facade consultants

Ground Settlement.

ML1-JAI- EIA-ROUT-XX-DR-Y-21146 rev P02

ML1-JAI-EIA-ROUT\_XX-DR-Y-21146

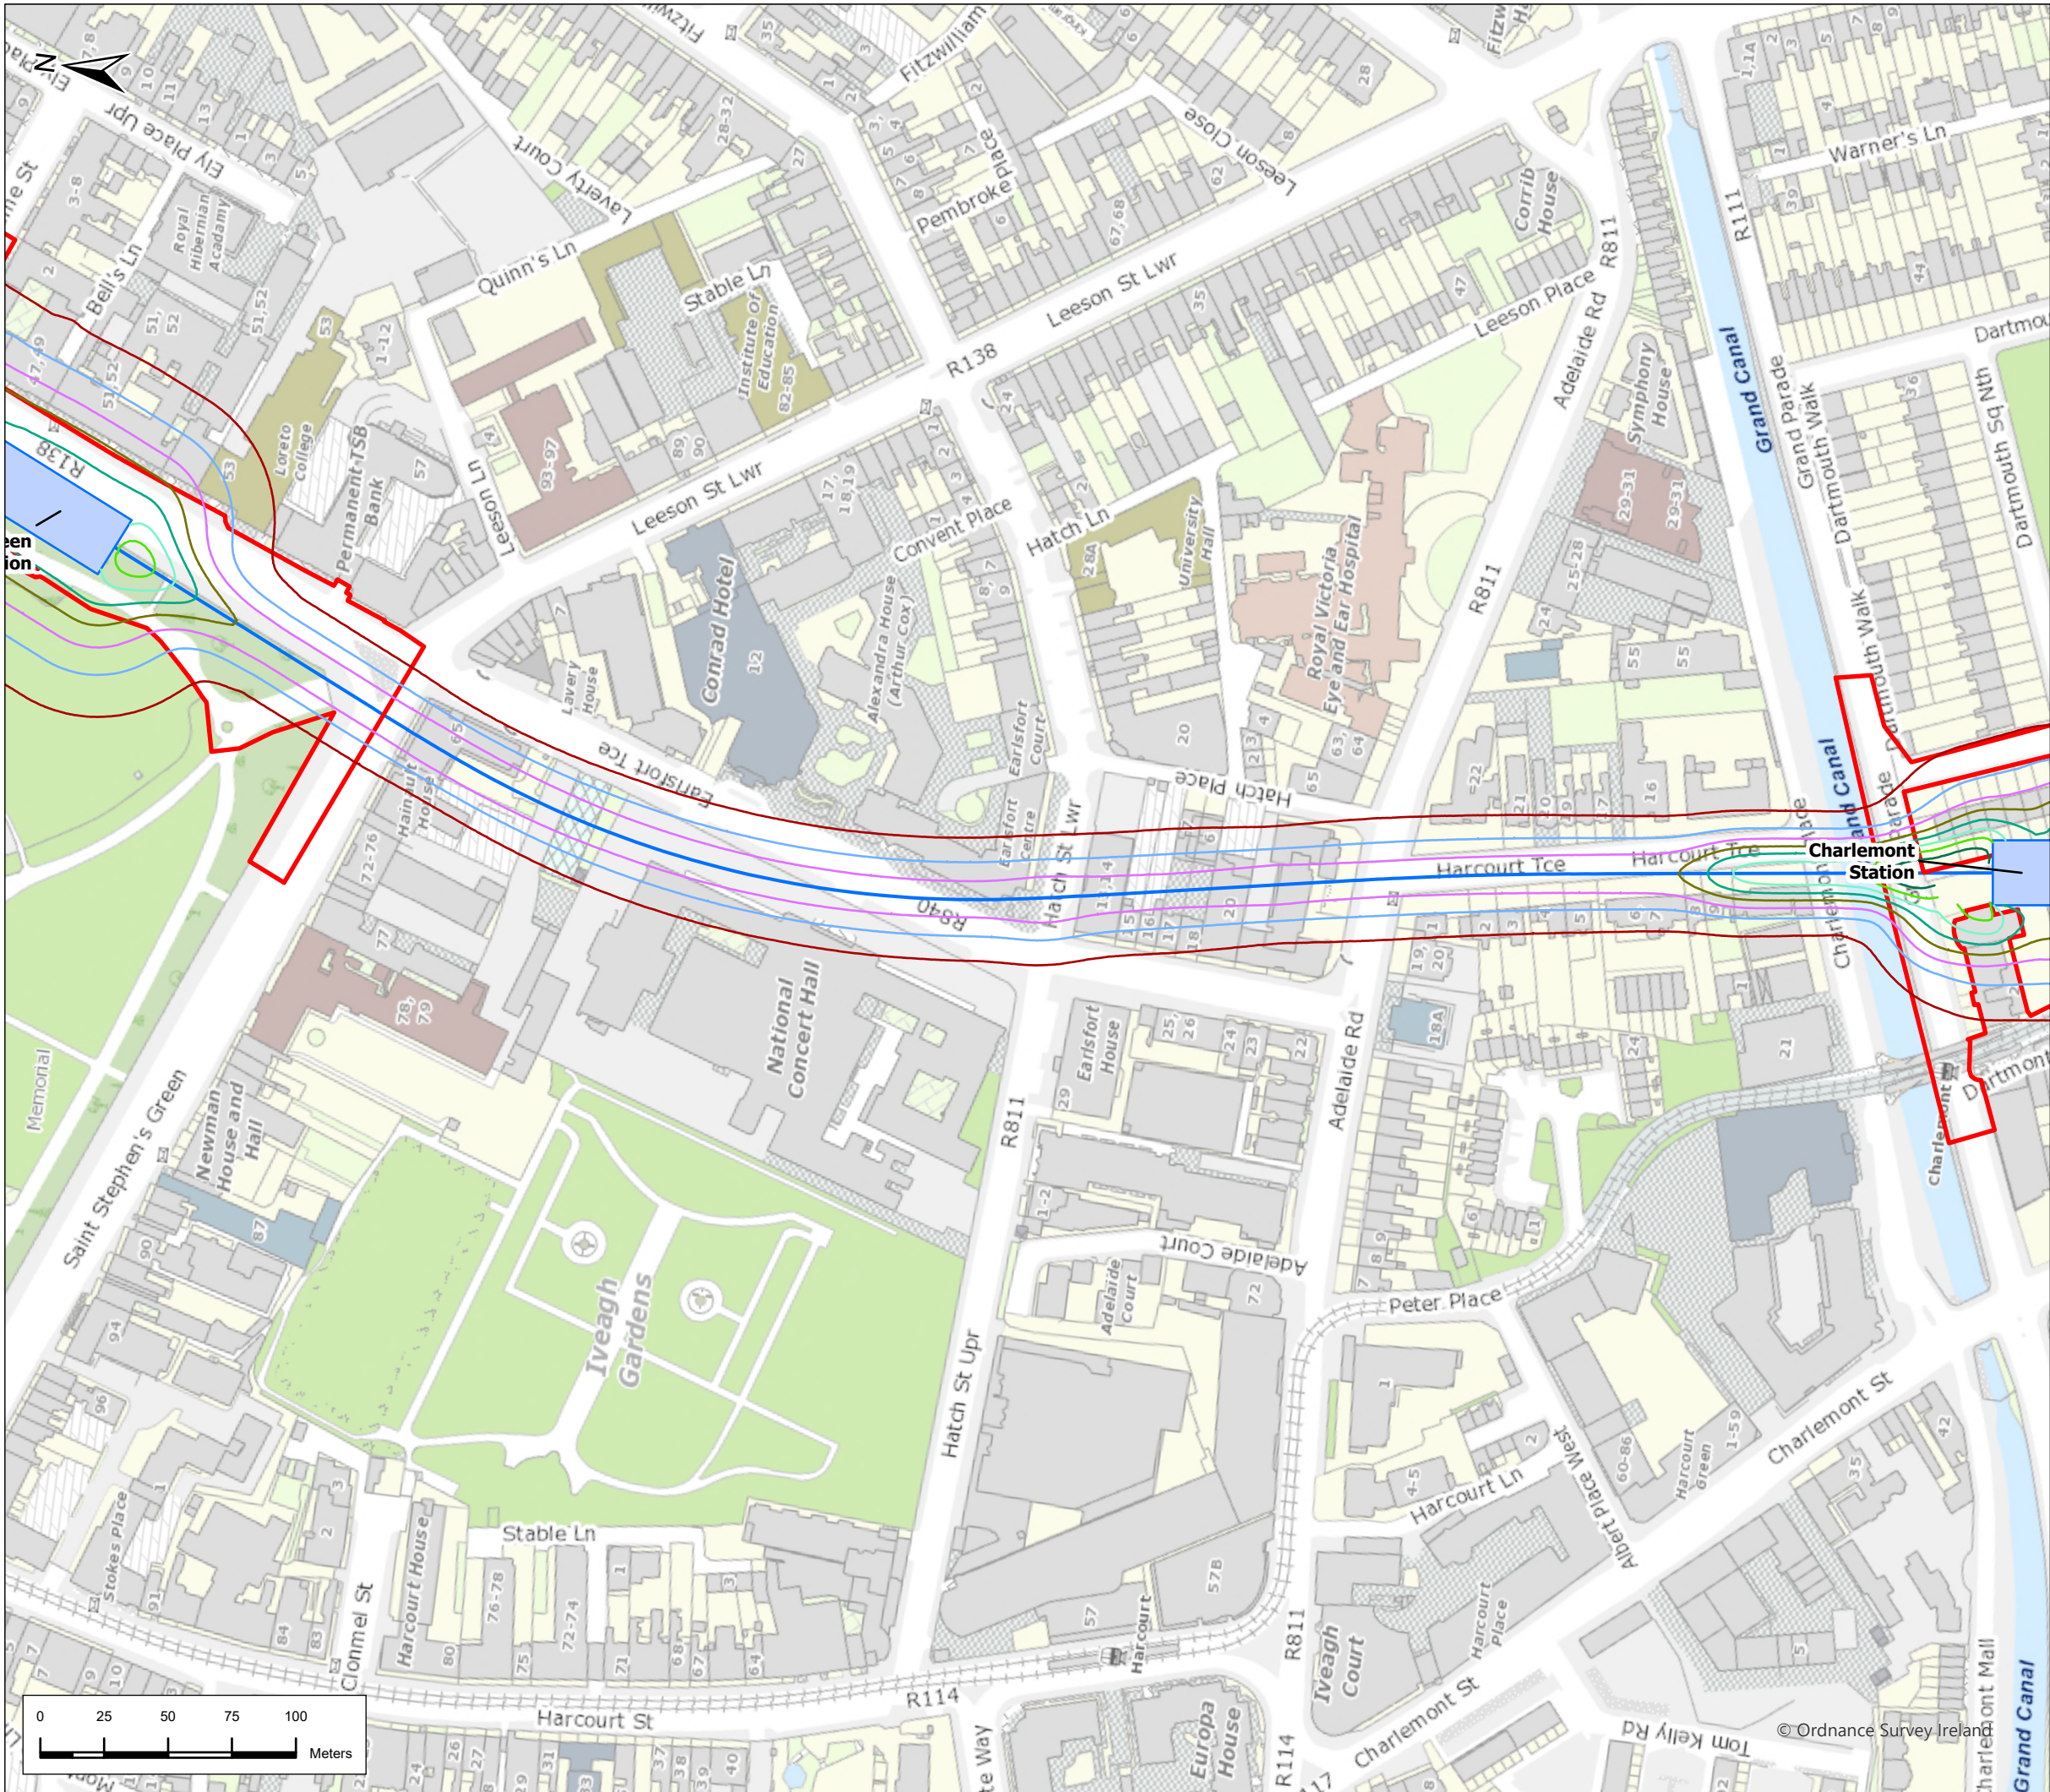
Due to the aspect ratio of the panels closest to gridline D on the South elevation, the TII predicted differential settlement of **25mm from Gridline C to D** would result in **1.75m** wide panels rotating in plane not less than **3.6mm** at their base. As each panel is **3.5m tall this translates into 7mm rotation** at the top corner of the panel. Such rotation would exceed the design parameters of the structural sealant at the glass to glass joint crushing and tearing the sealant and inducing stress in the glass. It may not cause breakage but will apply long-term stress into the structural sealant joint which may cause failure of the structural connection.

The differential settlement of a column **25mm from Gridline C to D** causes rotation of the connection between horizontal and vertical veil elements. These connections are typically formed with countersunk fixings tapped into a block of stainless steel. These connections were not designed to accommodate significant rotation. Detailed analysis would be required to determine how these connections react and whether the horizontal beams of the veil would rotate at these connections or be forced to go into bending (**'S' shaped bend on elevation**). If over-stressed the connections could fail.

If the horizontal beams or vertical mullions go into bending due to differential settlement, this could cause **over-stressing of the fixings in the stone exceeding permissible safety factors and/or causing cracking of the stone.**

When the structure moves differentially, the mullions remain vertical and the transoms rotate in plane. As each glass unit sits on a transom, the glass rotates with the transom. Based on the TII diagram there is approximately **30mm of differential settlement across quite a small width of approximately 10m.** Due to the aspect ratio of the panels closest to gridline D1 on the South elevation, the TII predicted differential settlement of **30mm in this area** would result in **1.5m wide panels** rotating in plane not less than **4.5mm at their base**. As each panel is **3.8m tall** this translates into **11mm rotation** at the top corner of the panel. The toggle glazed system does not have capacity for this degree of movement.

If the tunnel is out of position to the West by 10m or 15m which we understand is within the TII's tolerances, you can see the curved glass screen will be in danger of experiencing **major differential settlement across the south** end of the screen which would cause breakage.
